**SSD 5249 MOD 1
1 LAWSON SQUARE, REDFERN**

This letter has been prepared on behalf of Lawson Square Pty Ltd with regard to State Significant Development (SSD) 5249 – 2012 relating to Lawson Square, Redfern. The purpose of this letter is to respond to the City of Sydney Council's (Council) submission dated 1 October 2015. We note that Council have raised no objections to the proposed relocation of uses, however, they raised three items for further consideration. These items are addressed in turn below. This response should be read with reference to the following plans prepared by Candalepas Associates + Wendy Lewin (submitted separately):

CAD FILE NO:
DRAWING No:
S96 - 1103

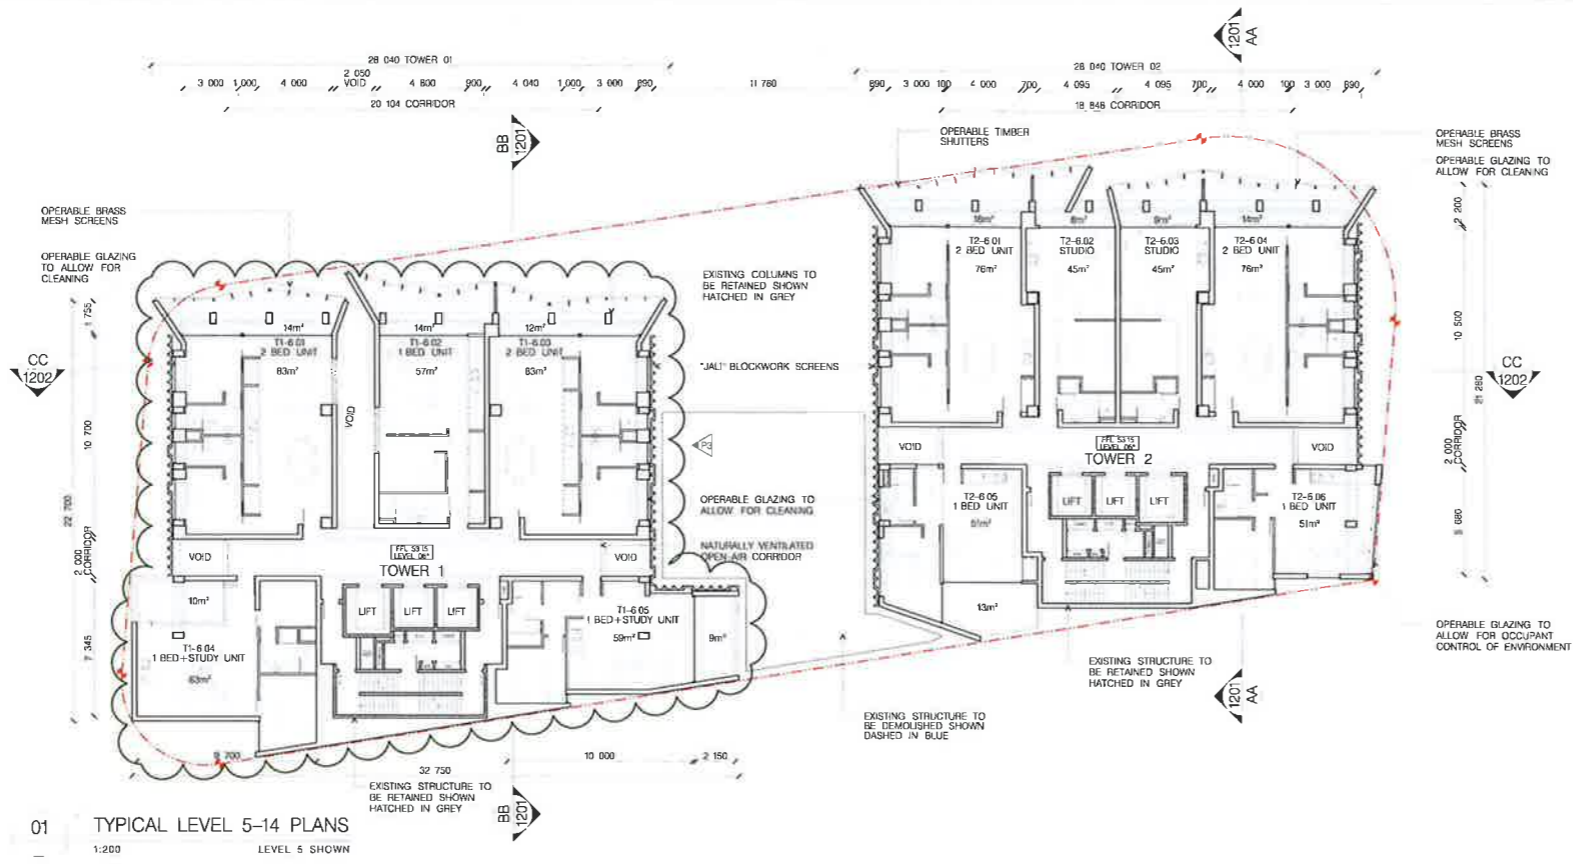
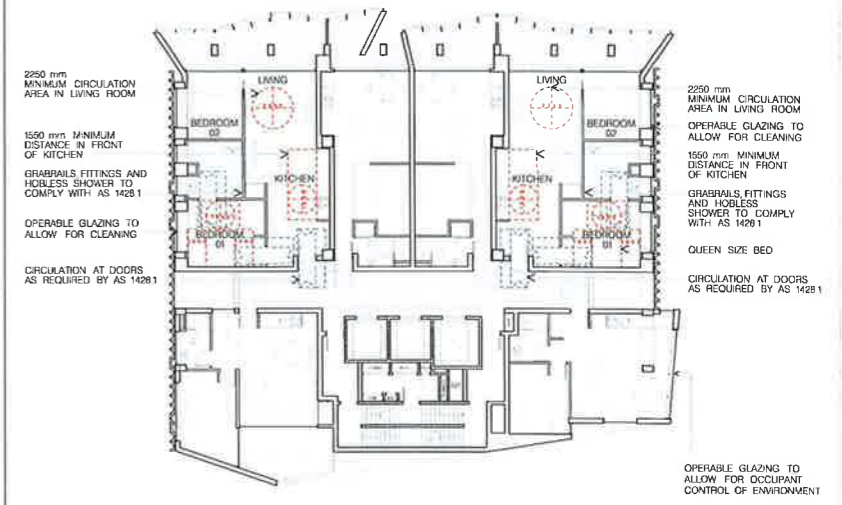
“The replacement of residential uses with the commercial tenancy on levels 1 to 5 from Tower 1 to Tower 2 has resulted in the removal of windows on the eastern elevation and loss of balconies and windows on the southern elevation of Tower 2. Consideration should be given to retaining the eastern elevation windows and improving articulation along the southern elevation on these levels.”

The proposal has been amended to include windows on the southern façade of Tower 2 at Levels 1 - 4. This has increased the articulation of the building when viewed from Redfern Street Lane and Regent Street (refer to Figures 1 & 2 below).
